**PACIFIC HIGHWAY (H10) - SSI 9837: NEWCASTLE POWER STATION PROJECT, LOT: 2 & 3
DP: 1023561, 1940 PACIFIC HIGHWAY TOMAGO**

TfNSW have reviewed the Environmental Impact Statement Submissions Report (the Report) prepared by AGL, dated April 2020, and relevant Appendices. While it is acknowledged the Report addresses some of the comments previously provided by TfNSW, TfNSW note still there are unresolved issues with the proposal.

Figure 3-1: Site access location off Old Punt Road

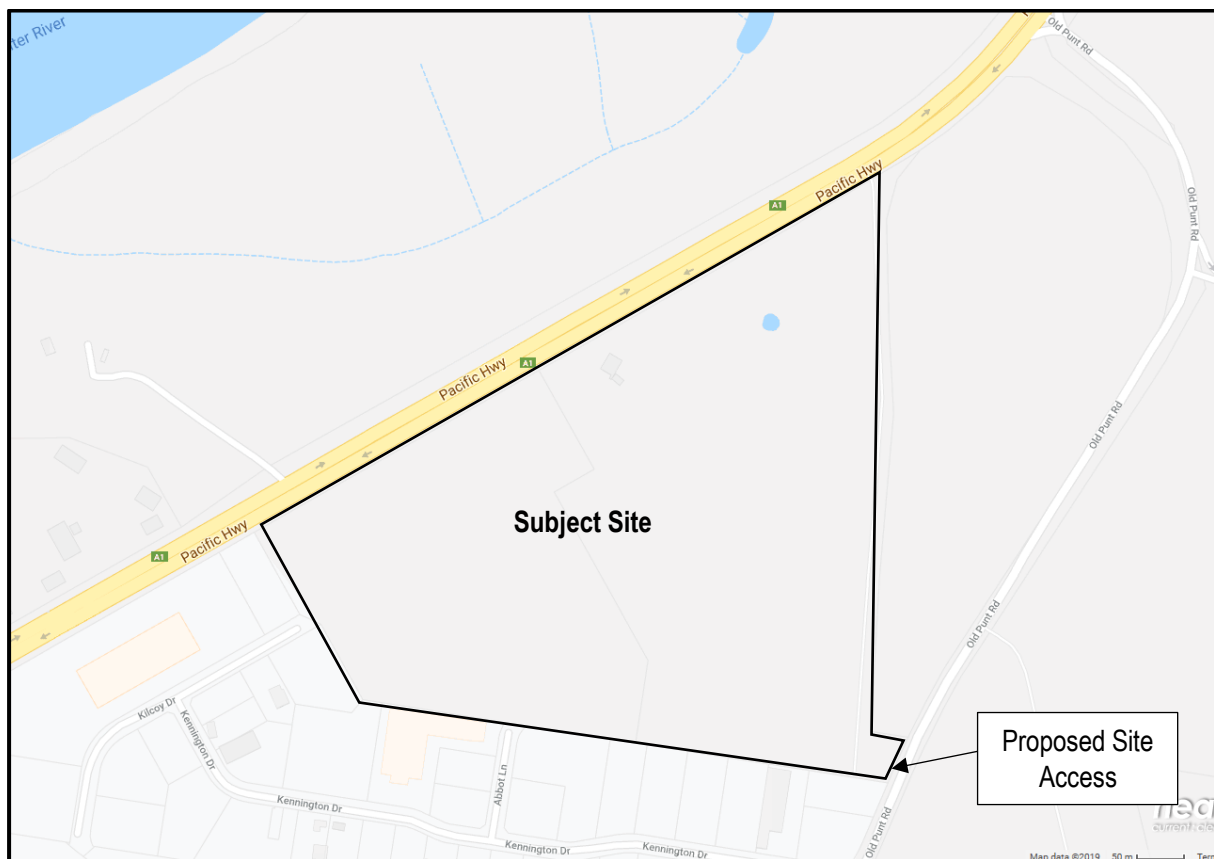
10	<p>The proposed access from Old Punt Road would need to be adapted to the proposed Transport upgrade to Old Punt Road. The NPS proposal shall include the upgrade of Old Punt Road to accommodate the largest service vehicles accessing the AGL site as part of the AGL project. Further design will be required from AGL and will need to be adapted to fit to the upgrades required on Old Punt Road. In order to allow for right turns into the site access to occur in a safe, a channelised right turn treatment (CHR(S)) on Old Punt Road southbound has been proposed.</p>	<p>The road and intersection upgrade would be the responsibility of AGL. The upgrade work should comply with relevant standards appropriate for major heavy vehicle access.</p>	Partial	<p><i>T-5: A CHR turn treatment on Old Punt Road is required to allow for the safe movement of construction traffic turning right into the site and to prevent queuing of vehicles along Old Punt Road. This must be designed in accordance with the Austroads Guidelines and to the satisfaction of PSC and Transport for NSW.</i></p> <p>The above condition is suitable with the additional comments included:</p> <ul style="list-style-type: none"> • This would include full pavement reconstruction across the full road width that adapts to the M12RT design. • The trenching of the gas utilities is in the location of the proposed intersection. The conditions would include full protection of the gas utility and pavement reconstruction within the scope of the intersection upgrade. • Upgrade to the intersection prior to substantial works commence on site. <p><i>T-8: AGL would design the access from Old Punt Road to integrate appropriately with any development proposal designs for the upgrade of Old Punt Road that are exhibited prior to commencement of the construction of the Proposal.</i></p> <p>T-8 is inadequate as AGL could start construction immediately after EIS approval and the commitment is negated. TfNSW is targeting display of the EIS in 2021 but is in a position to provide more than adequate information to enable the AGL proposal to progress.</p> <p>Proposed changed wording: <i>T-8: AGL would design the access from Old Punt Road to integrate appropriately with any</i></p>
